Engineers comments regarding condition 3- surface water drainage

NOTIFICATION FROM ARUN DISTRICT COUNCIL
TOWN AND COUNTRY PLANNING ACT 1990
APPLICATION **FG/62/19/DOC**

Site Address: Ferring Country Centre And Riding Stables Rife Way Ferring
BN12 5JZ

Description of Works: Approval of details reserved by condition imposed under FG/203/18/PL relating to conditions 3-surface water drainage, 4-details of materials & finishes, 5-Construction Management Plan & 6-covered & secure cycle parking spaces.

Drawing 6454 Proposed Surface Water Drainage

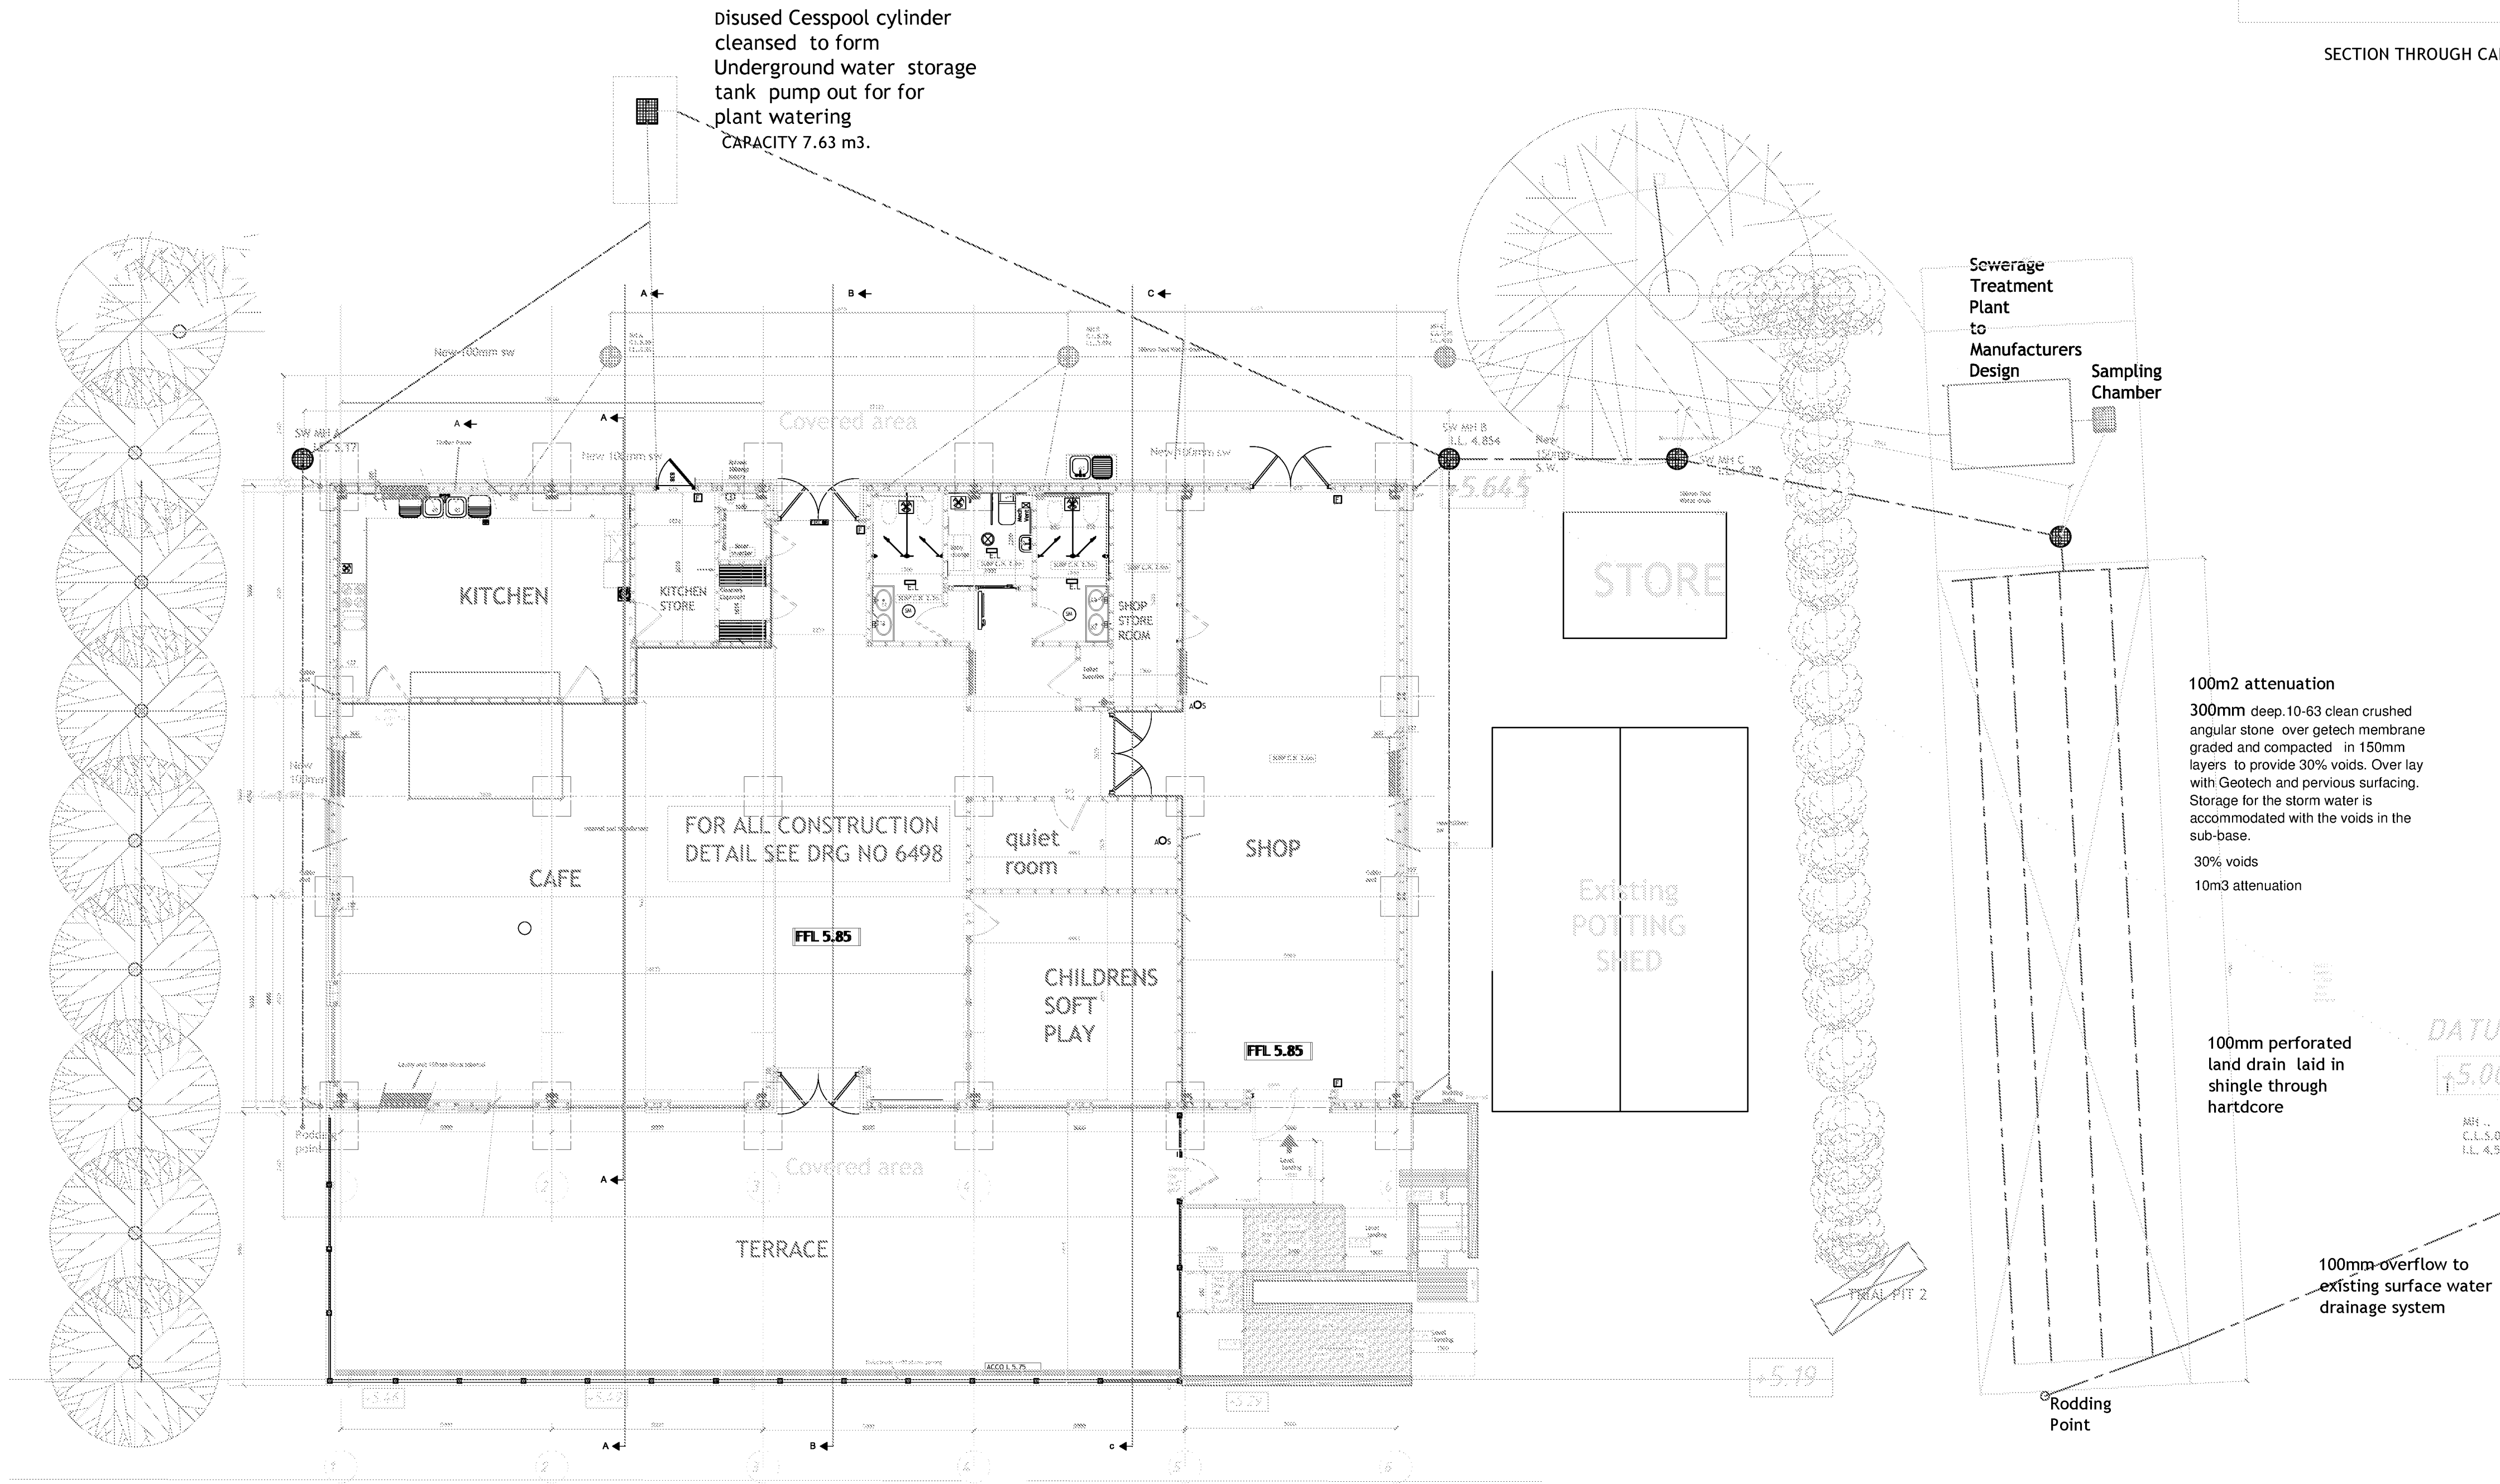
3. It is unclear where the assumption that only 50% of the roof runoff requires storage within the sub-base has been derived from.
4. The existing soakaway should not be included within calculations as it has been found that this may not be utilisable at times of high ground water. The proposals for a high level overflow connecting to this can be taken forwards if it is found to be required.

5. Half drain time calculations should be submitted.
6. Cover levels need to be provided at manholes.
7. Invert and cover levels need to be provided on plan of the overflow pipe and the manhole upstream of the permeable surface area.

8. Finish and formation levels of the permeable surface need to be provided. Please also specify if a flat sub base is to be provided or not.
9. Please can results from the infiltration tests that are referred to be supplied as part of this application.
